**WELWYN HATFIELD BOROUGH COUNCIL
EXECUTIVE DIRECTOR - PLANNING, PUBLIC PROTECTION AND GOVERNANCE**

DELEGATED APPLICATION

Application No: 6/2021/2571/FULL
Location: Judges Judge's Hill Northaw Potters Bar EN6 4NL
Proposal: Erection of a single storey building to rear for use as additional dining space for existing restaurant
Officer: Ms Ashley Ransome

Recommendation: Refused

1 Judges Hill, Northaw, Potters Bar EN6 4NL
EXISTING GROUND FLOOR PLAN

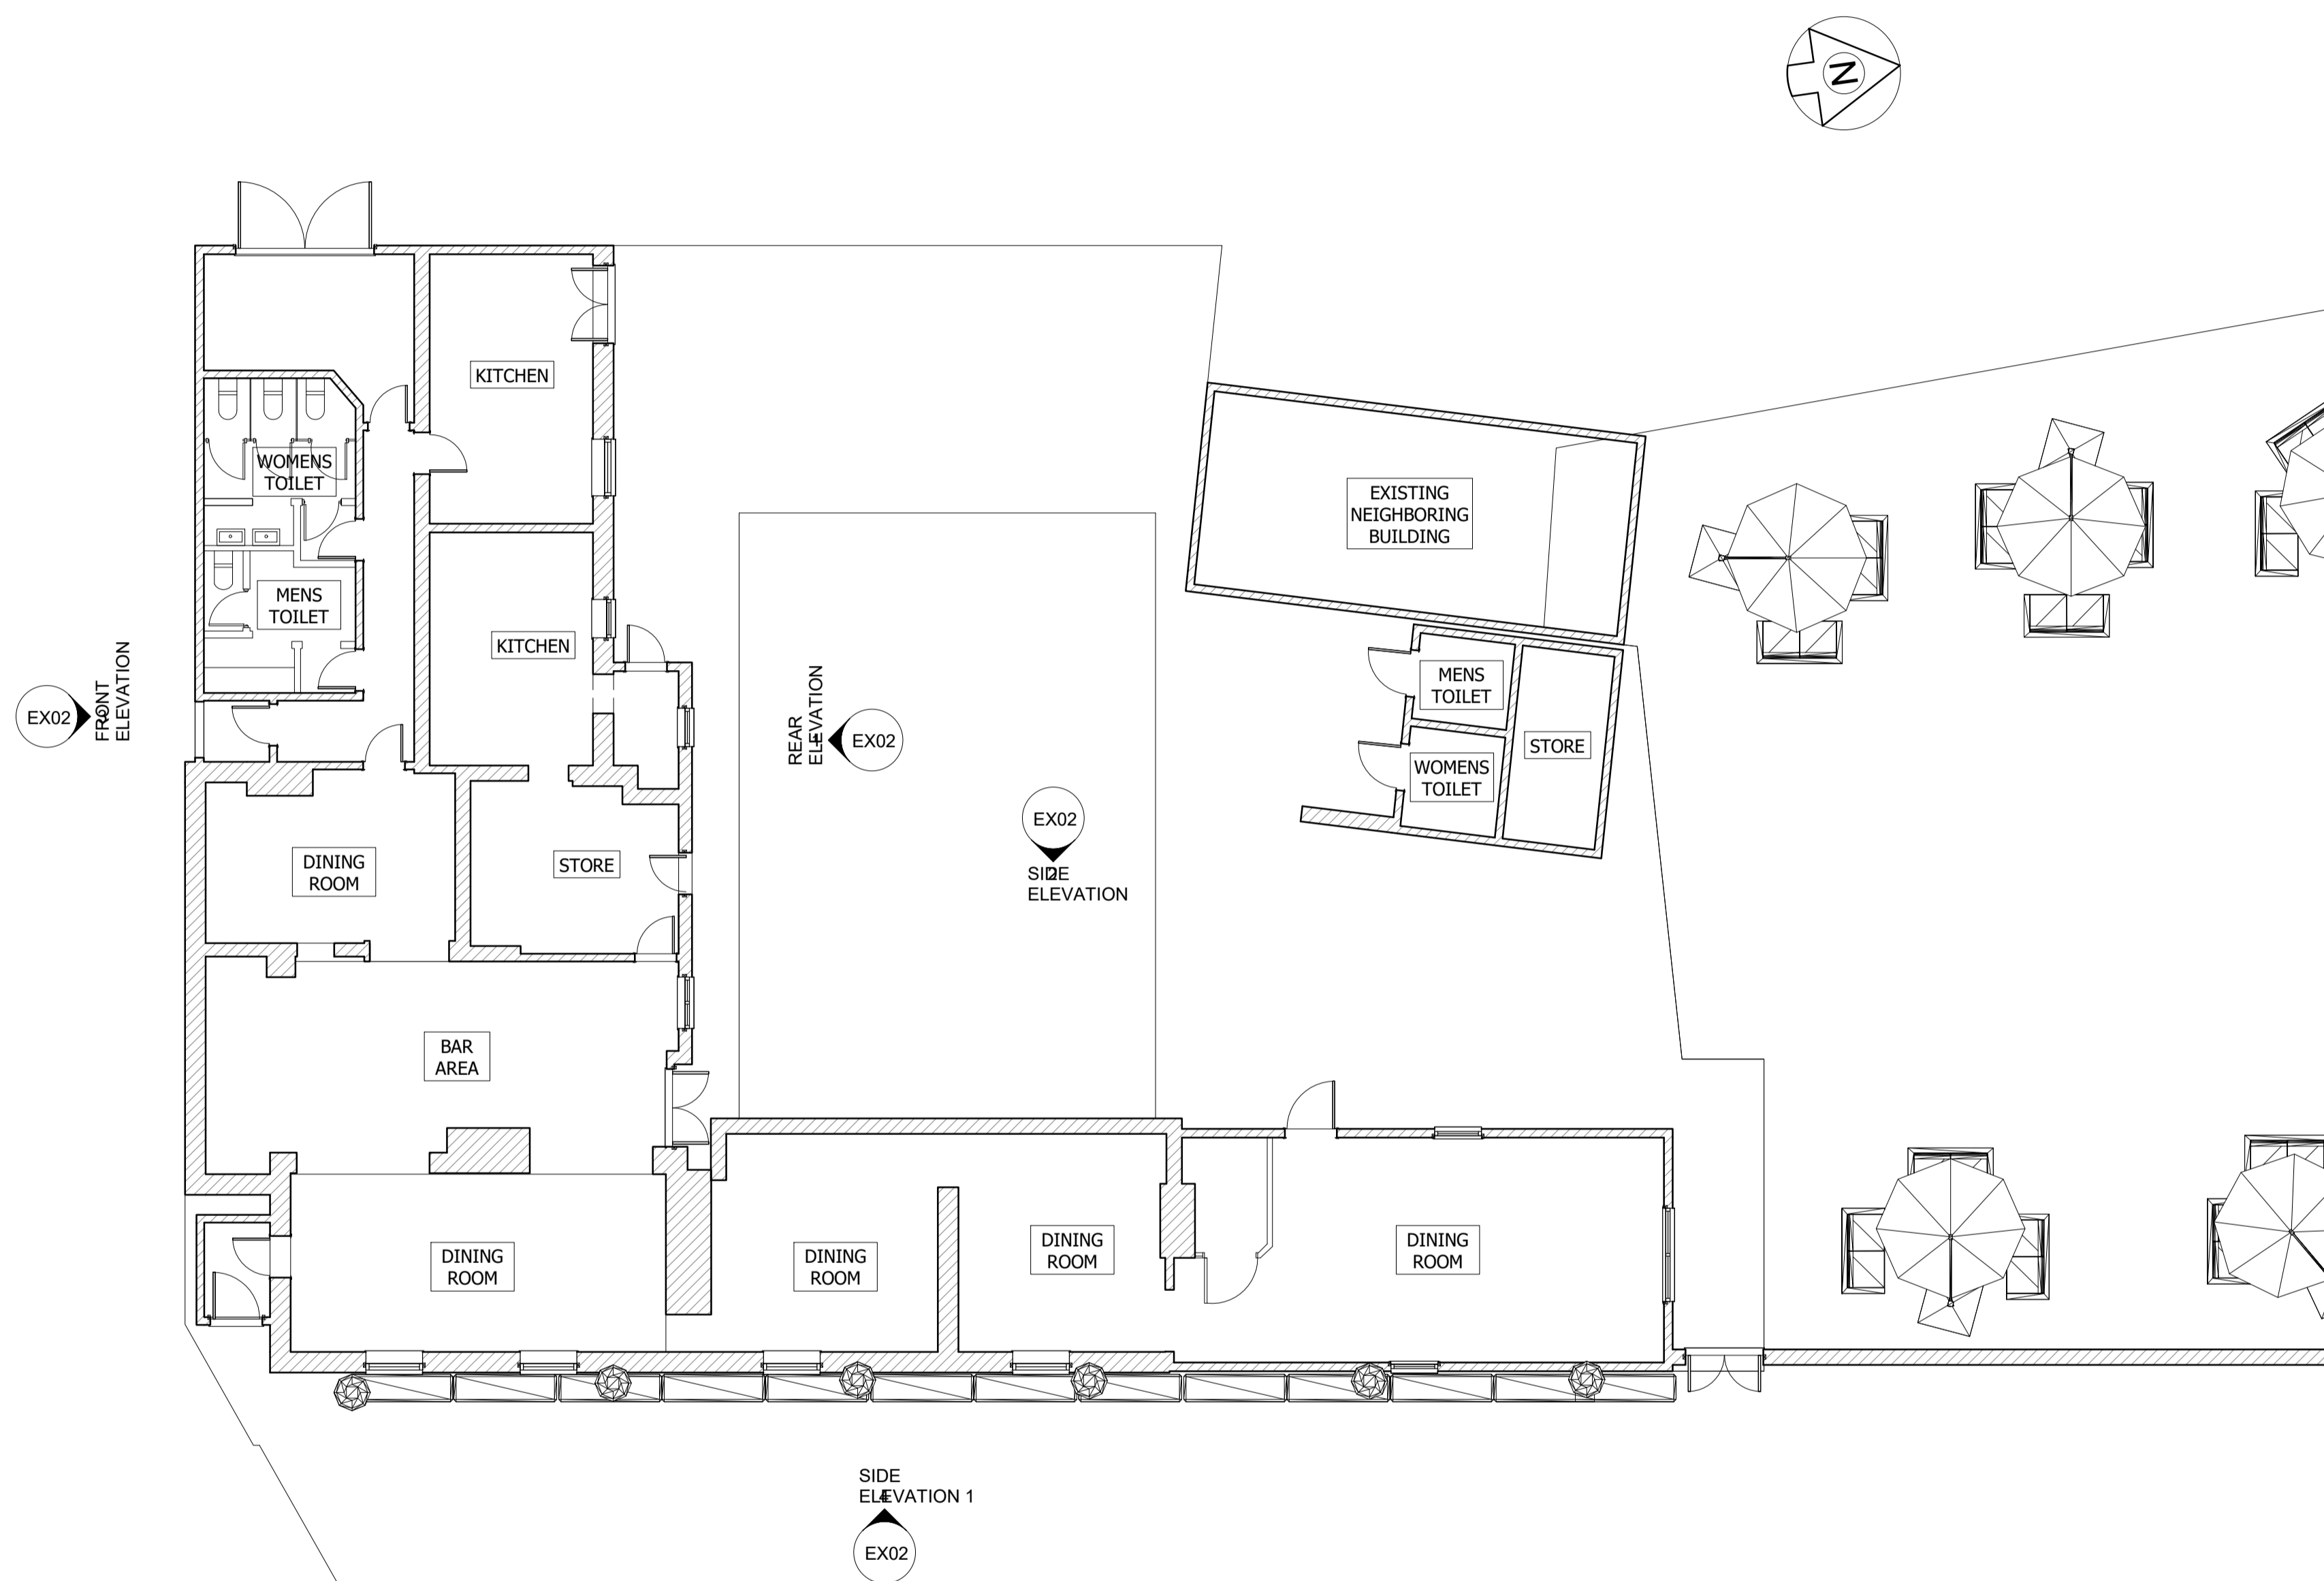
It should be noted that the existing plans submitted within the current application do not show the unauthorised single storey extension that is currently in place at the site.

4. Insufficient information has been submitted, by way of incorrect plans, due to the existing unauthorised structure not being included, along with other large canopies on site. A comprehensive assessment of the impact the unauthorised/ proposed structures are having/would have on this site can therefore not be undertaken.

1 Judges Hill, Northaw, Potters Bar EN6 4NL  
**GROUND FLOOR PLAN & SITE PLAN**

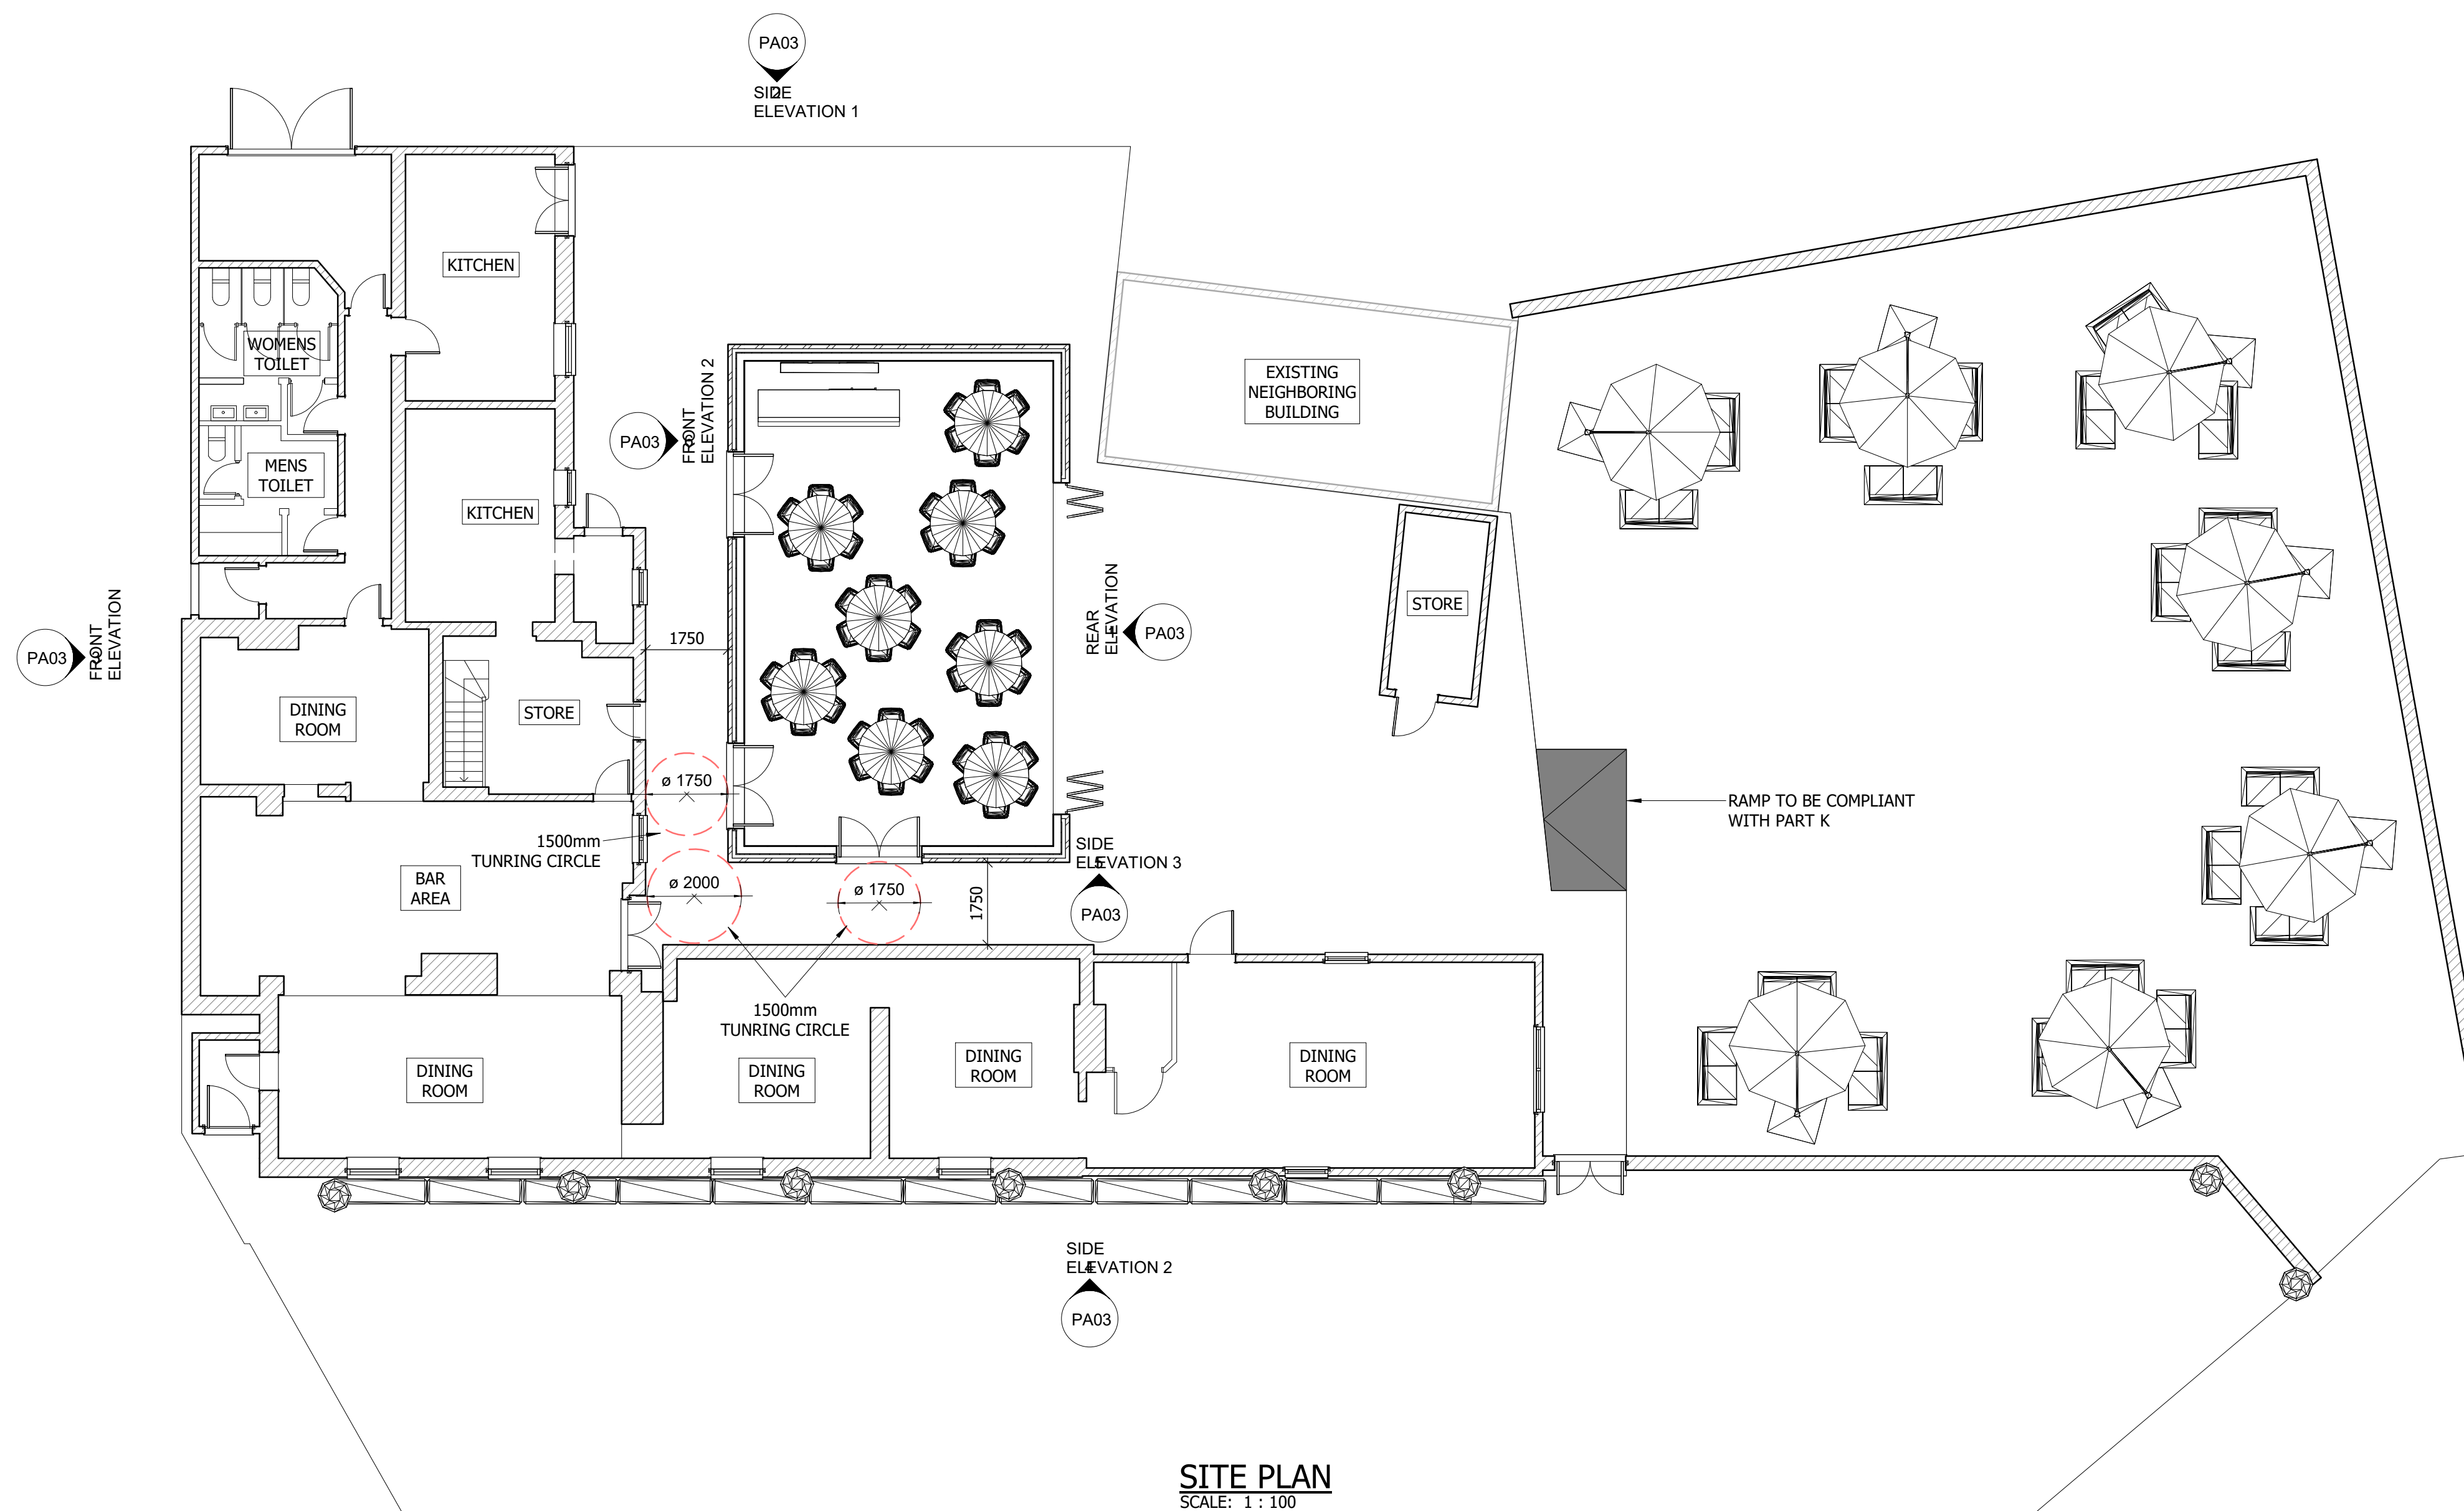
Notwithstanding the above development that is still insitu at the site, as part of the application it is presumed that the single storey extension is to be removed as it does not appear on the existing or proposed plans. The proposed outbuilding would create a floor space of approximately 80m². This addition, taken cumulatively with the existing additions would represent an approximate 57% increase above the size of the original building.

In view of the above, it is considered that the proposal would result in disproportionate additions over and above the size of the original building and therefore represents inappropriate development in the Green Belt. The proposed development is therefore contrary to the NPPF, Policies GBSP1 and RA2 of the Welwyn Hatfield District Plan 2005 and Policy SADM34 of the Welwyn Hatfield Draft Local Plan 2016.

1. The proposed development would constitute an extension or alteration, together with previous additions, that would result in disproportionate additions over and above the size of the original building. Therefore, the proposal equates to inappropriate development in the Green Belt. There would be other harm due to the loss of the openness of the Green Belt. Other considerations would not clearly outweigh the harm by reason of inappropriateness and loss of openness. Consequently, the very special circumstances required to approve inappropriate development in the Green Belt do not exist. The proposed development would be contrary to Policies GBSP1 and RA2 of the Welwyn Hatfield District Plan 2005, Policy SADM34 of the Welwyn Hatfield Draft Local Plan 2016 and Section 13 of the National Planning Policy Framework.

**1 Judges Hill, Northaw, Potters Bar EN6 4NL**  
**PROPOSED ELEVATIONS**

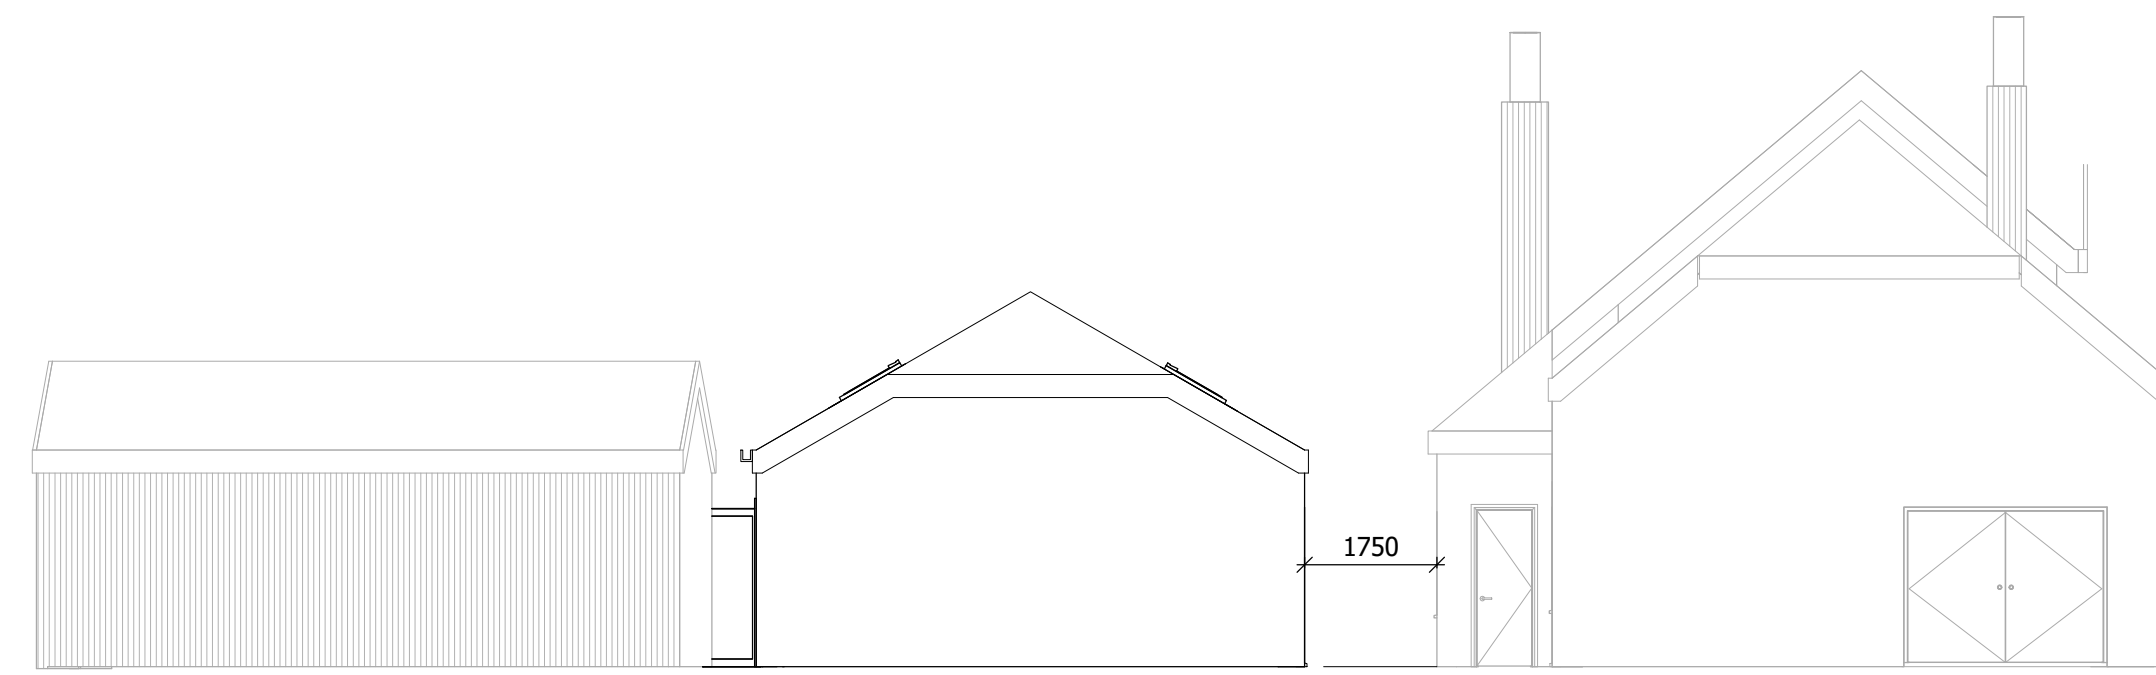
Notwithstanding the above, the NPPF does not limit the concept of proportionality to a mathematic assessment alone and an overall assessment of proportionality includes a qualitative assessment too. In terms of a visual assessment, the proposal would add further built form which will be visually prominent.

2. The proposed development would materially harm the character and significance of a designated heritage asset and the setting of a listed building. In addition, the proposed design of the structure means that it would have a detrimental impact on the conservation area and the character of the area. As no justification has been provided which would outweigh the harm to the character and significance of these designated heritage assets, there are no benefits which outweigh this harm. As such, the proposal is contrary to Policies D1 and D2 of the Welwyn Hatfield District Plan 2005, Policies SP9 and SADM15 of the Welwyn Hatfield Draft Local Plan 2016, the National Planning Policy Framework and Section 66(1) of the Planning (Listed Buildings and Conservation Areas) Act 1990.

3. No information has been provided to demonstrate sufficient noise mitigation and to provide the insulation properties of the structure to control noise breakout. The proposed development would therefore exacerbate the noise issues at the site facilitate a continuation, in part, of the unacceptable level of noise which is currently being produced by the activities on site. The proposal is therefore contrary to Policies D1 and R19 of the Welwyn Hatfield District Plan 2005, Policies SADM11 and SADM18 of the Welwyn Hatfield Draft Local Plan 2016 and the National Planning Policy Framework.
